Validity of Bat Surveys
152 High Street, Old Woking GU22 9JH

Ref: WEc_GU22

November 2023

Tree Removals and Tree Protection Plan

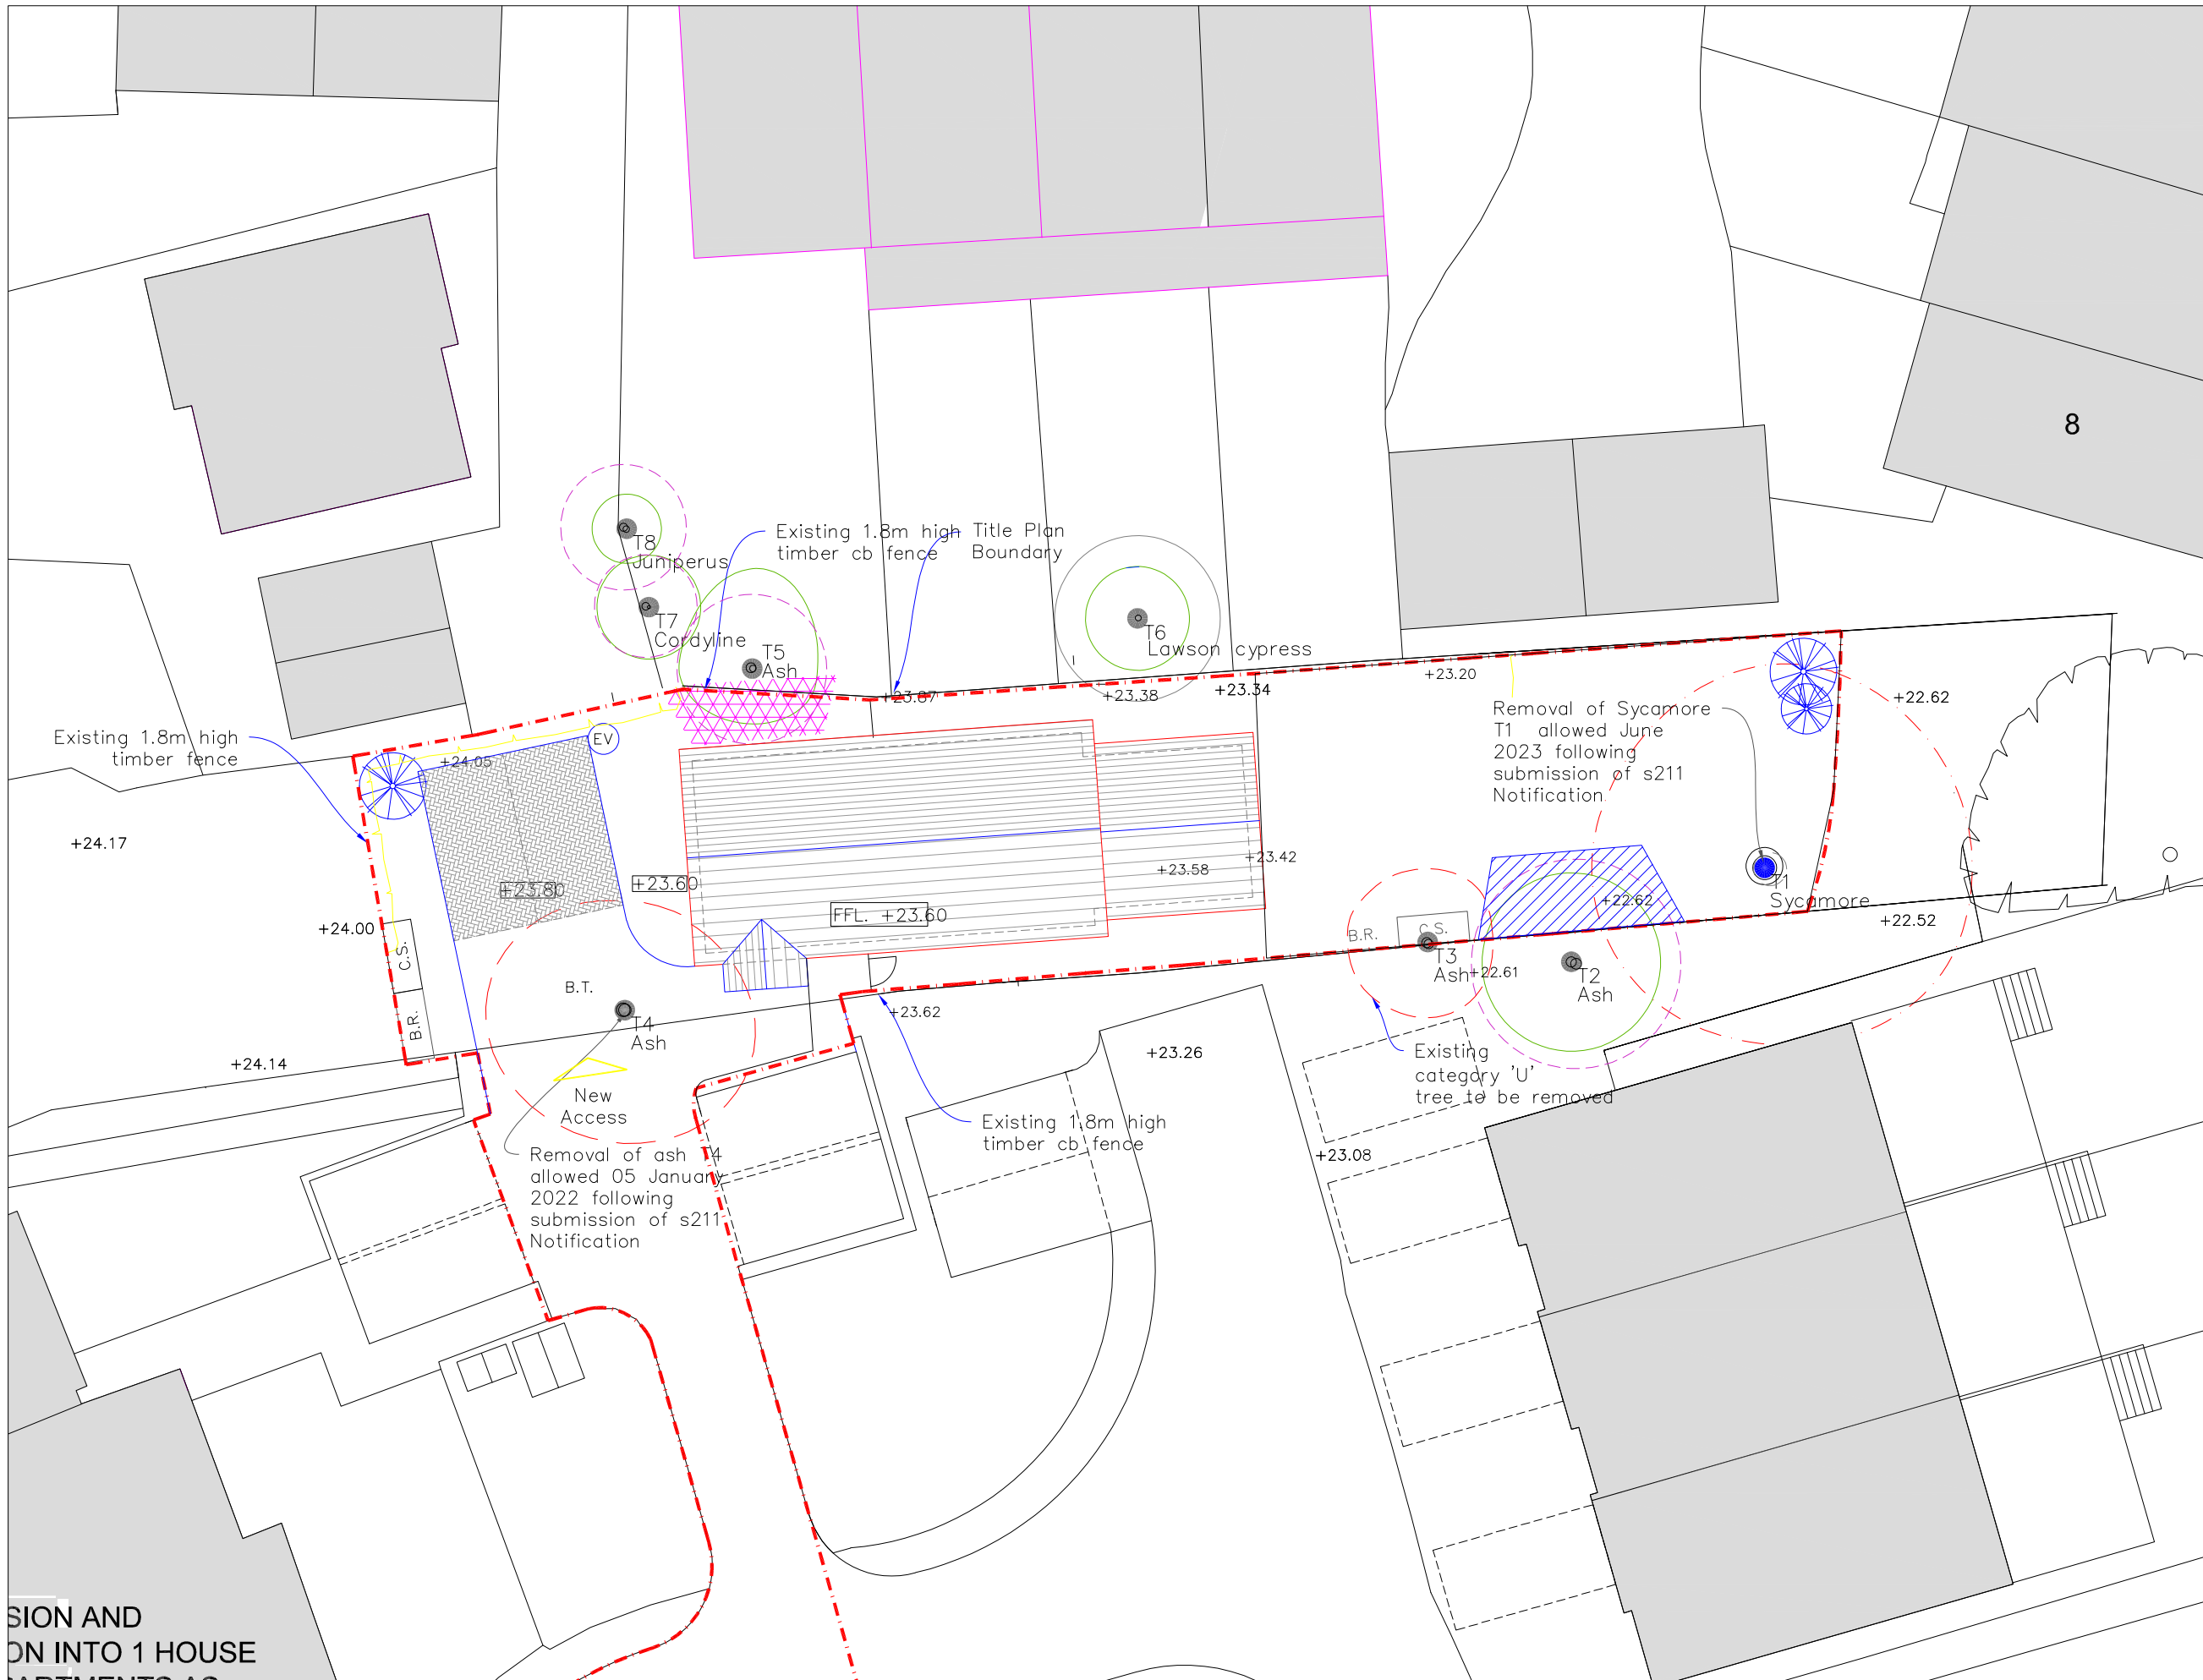
It is noted that the application site is laid to low level scrub/brambles/ivy, with no existing significant vegetation apparent, and sited adjacent to maintained private garden areas within the built-up urban area; therefore, the biodiversity implications of the proposal would be minimal. However, the tree mentioned above which is the subject of a s211 notification from 2022 along with an additional Ash Tree towards the south of the site are proposed to be removed as part of this application. It is apparent that these trees remain in place and demonstrate the capacity for potential bat roost features and, therefore, may have bat roosting suitability. Whilst the submitted Ecological Appraisal Report carried out by Wychwood Environmental Ltd dated January 2023 details the results of bat roost potential evaluation on sycamore trees on-site, it does not appear that the ash trees to be affected as a result of the development have been assessed for their suitability to support roosting bats. The proposed development, therefore, would result in works to trees which could result in loss or disturbance to active bat roosts. As such, it is acknowledged that one of the affected trees has a s211 notification but this tree, as noted, remains standing and therefore the owner would still have to comply with the ecological legislation as Bats are still protected. Surrey Wildlife Trust has commented on this application and raise concern over the loss of the aforementioned trees and advise that prior to determination of the planning application the ash trees proposed for removal should be subject to a bat preliminary ground level roost assessment, undertaken by a suitably experienced ecologist in line with best practice guidance.

As such, in the absence of a bat preliminary ground level roost assessment, the LPA cannot be satisfied that the proposed development would not lead to a detrimental impact on trees which are proposed to be removed and their suitability to support roosting bats or that the proposed development would not result in a net loss of biodiversity on the proposal site. The proposed development would, therefore, be contrary to Policy CS7 of the Woking Core

The trees on site were subject to a ground level tree assessment, following BCT protocols. These are considered to offer **negligible** potential to support roosting bats, with the exception of the mature sycamore tree in the south of the plot which has **low** potential for roosting bats in the ivy on an occasional basis. No further emergence/re-entry surveys are required. If this tree is due to be removed, it should be 'soft' felled and left in-situ for 24hrs. Wood should ideally be retained onsite as habitat piles.

The ash trees on site have **negligible** potential for bat roosts, and one sycamore tree on site has **low** potential for bat roosting in the ivy. Under current BCT guidelines this does not require further surveys, as stated in the updated PEA report (attached).
